Subject: Y/88/21/DOC

Subject: Y/88/21/DOC

Condition 5

SITE LAYOUT
(1:200)

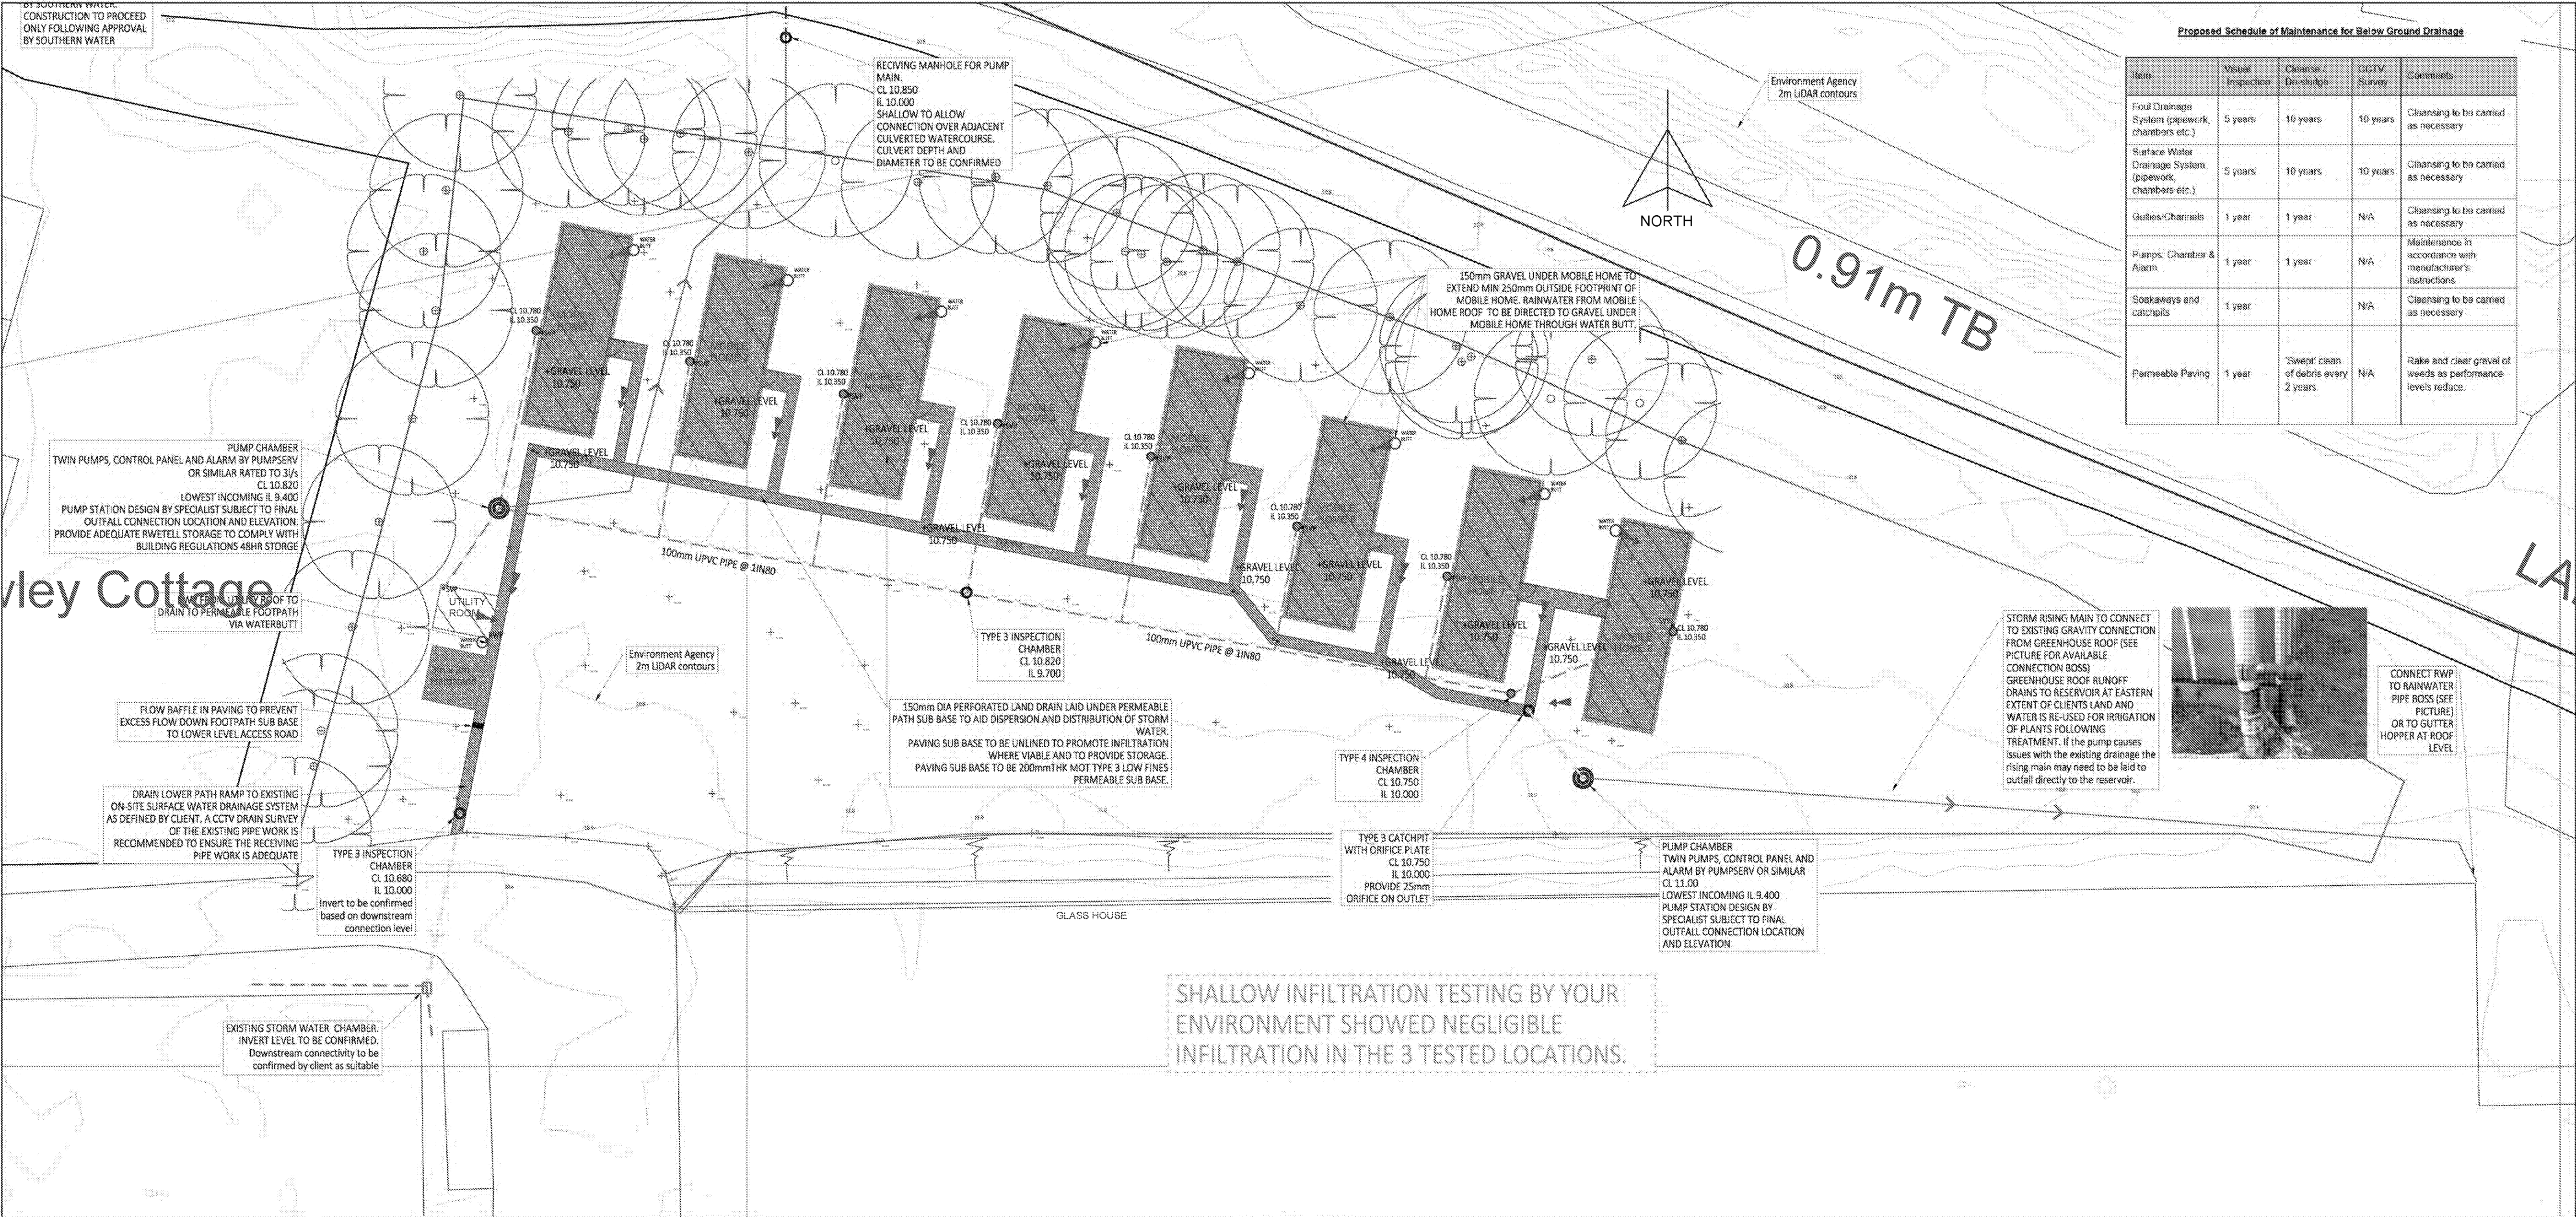
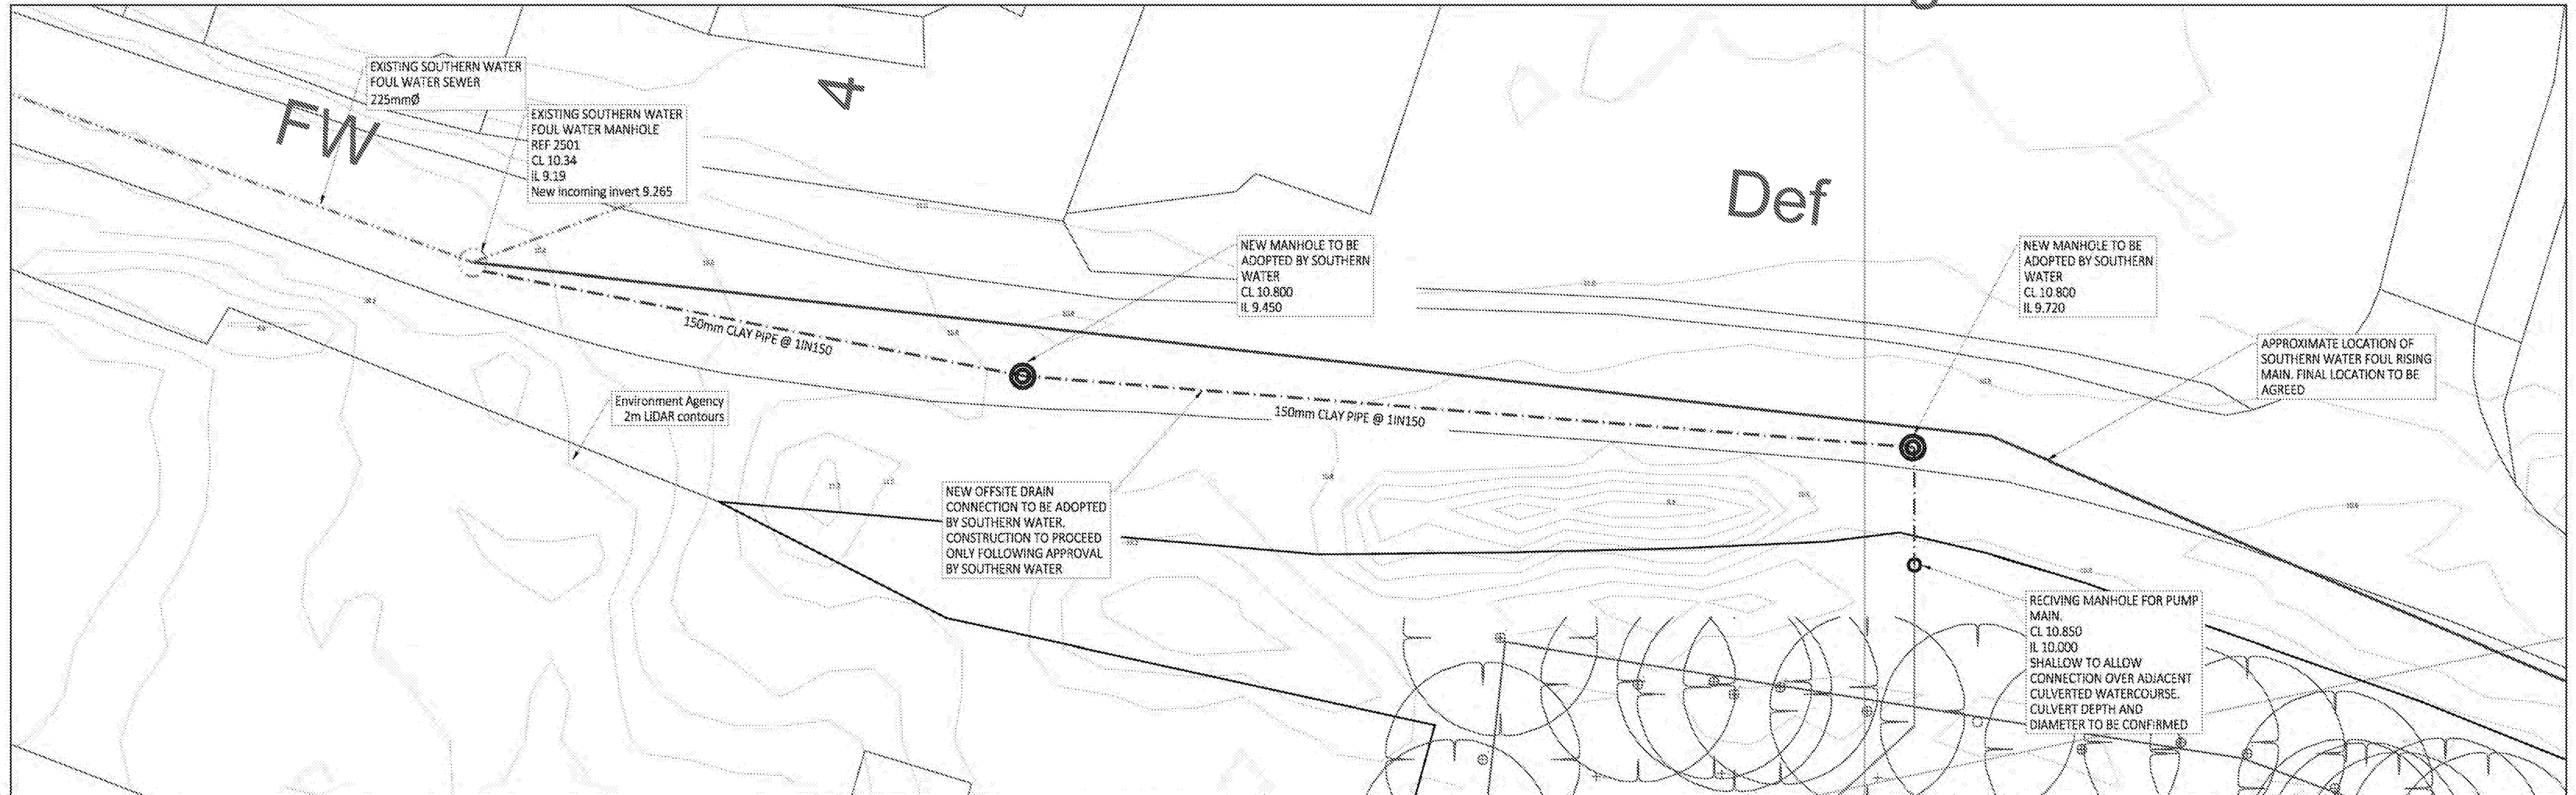
1. The applicant has completed summer infiltration testing which indicate infiltration is not viable.
2. No winter groundwater monitoring results have been provided, this information must be supplied to evidence that groundwater will not get into the surface water drainage system.

3. The proposal is for an unlined system to be pumped. This could in winter result in groundwater being pumped.
4. Pumping is not supported, it is not a sustainable solution. Pumps also fail and can result in increased flood risk both on and off site. The applicant must submit a revised gravity scheme.

5. The proposals are to pump surface water to the on site reservoir. The statement claims that no surface water will be discharged off site. No evidence has been submitted to evidence that either the existing surface water drainage network or reservoir have the capacity to accept these additional flows. The reservoir must also have an overflow to somewhere for water to be discharged in times of exceptional

rainfall when irrigation demands are less, i.e. the winter. Therefore the statements provided are not supported by ourselves.

It is not possible for us to recommend discharge of this condition at this time with the strategy presented. A fully revised surface water drainage design is required, which may involve a gravity outfall to watercourse.
